CBL: 059 A0080 **Permit ID:** 2013-02298

FIRST FLOOR PLAN
 SCALE 1/8"=1'-0"

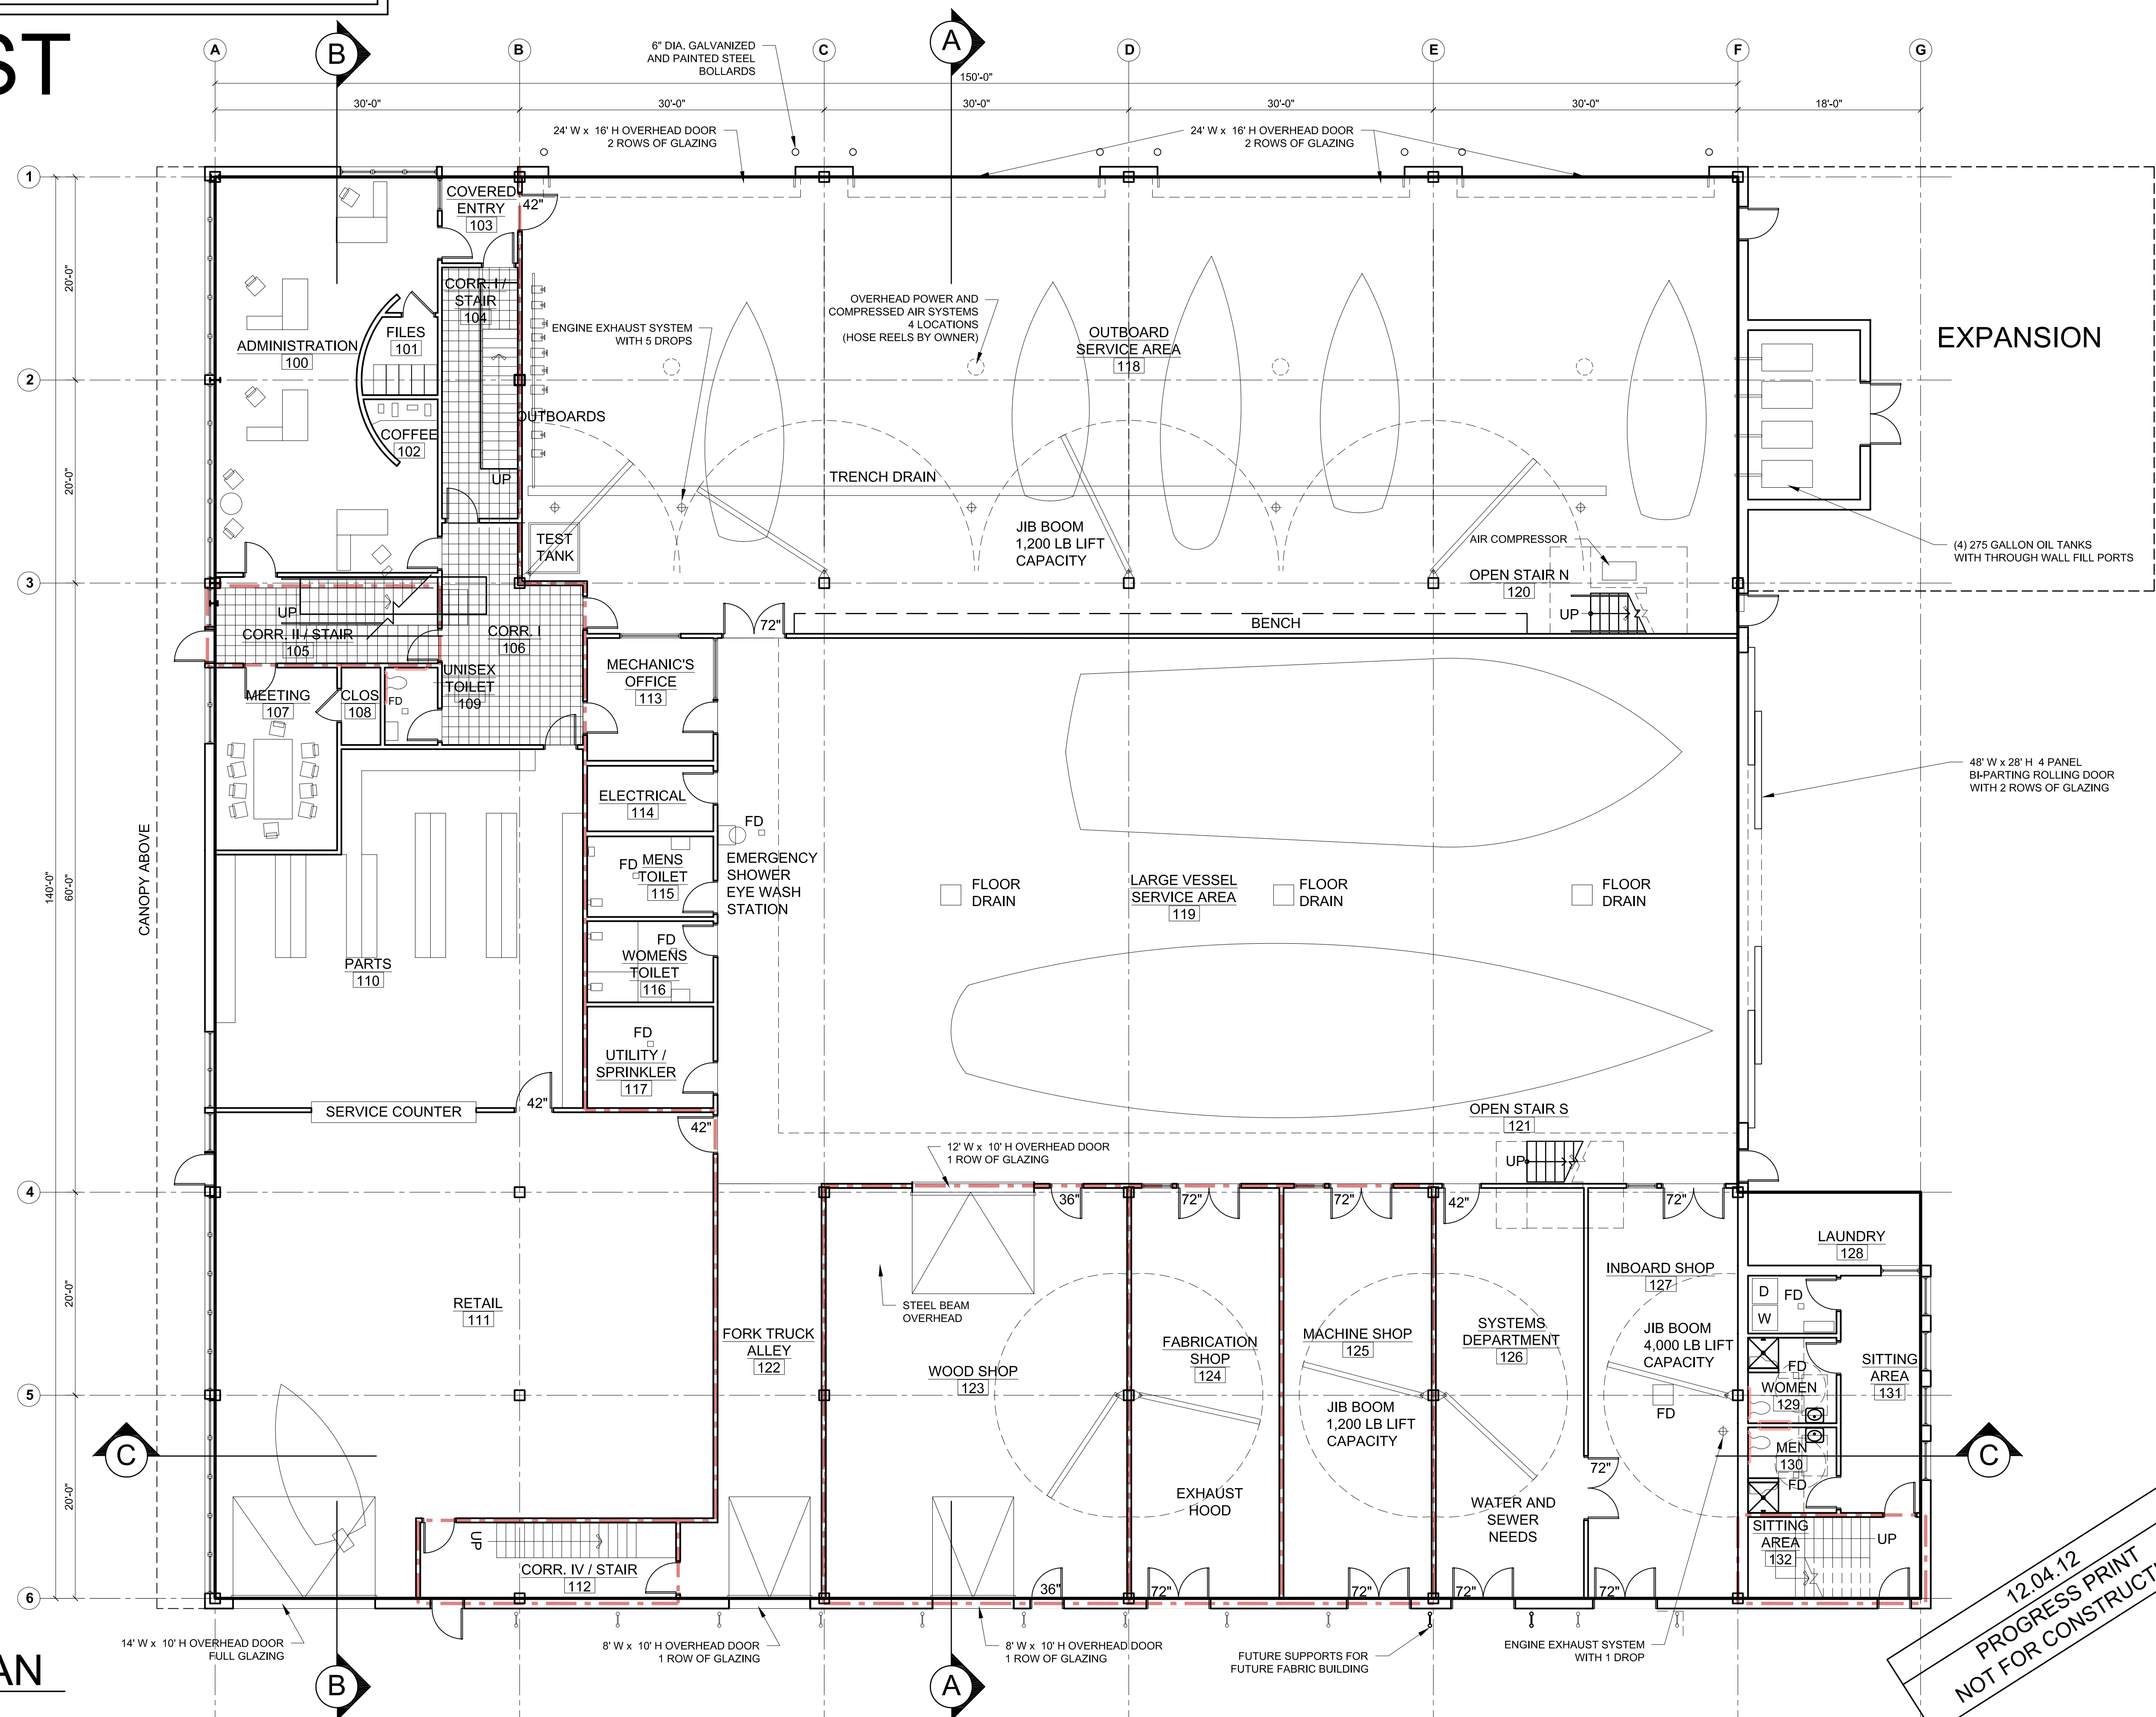
I need documented height of the building and also the elevation compared to the 65' above mean sea level. I need the first floor elevation shown on the plans too so I can prepare the floodplain forms. I sent an e-mail to Bob.
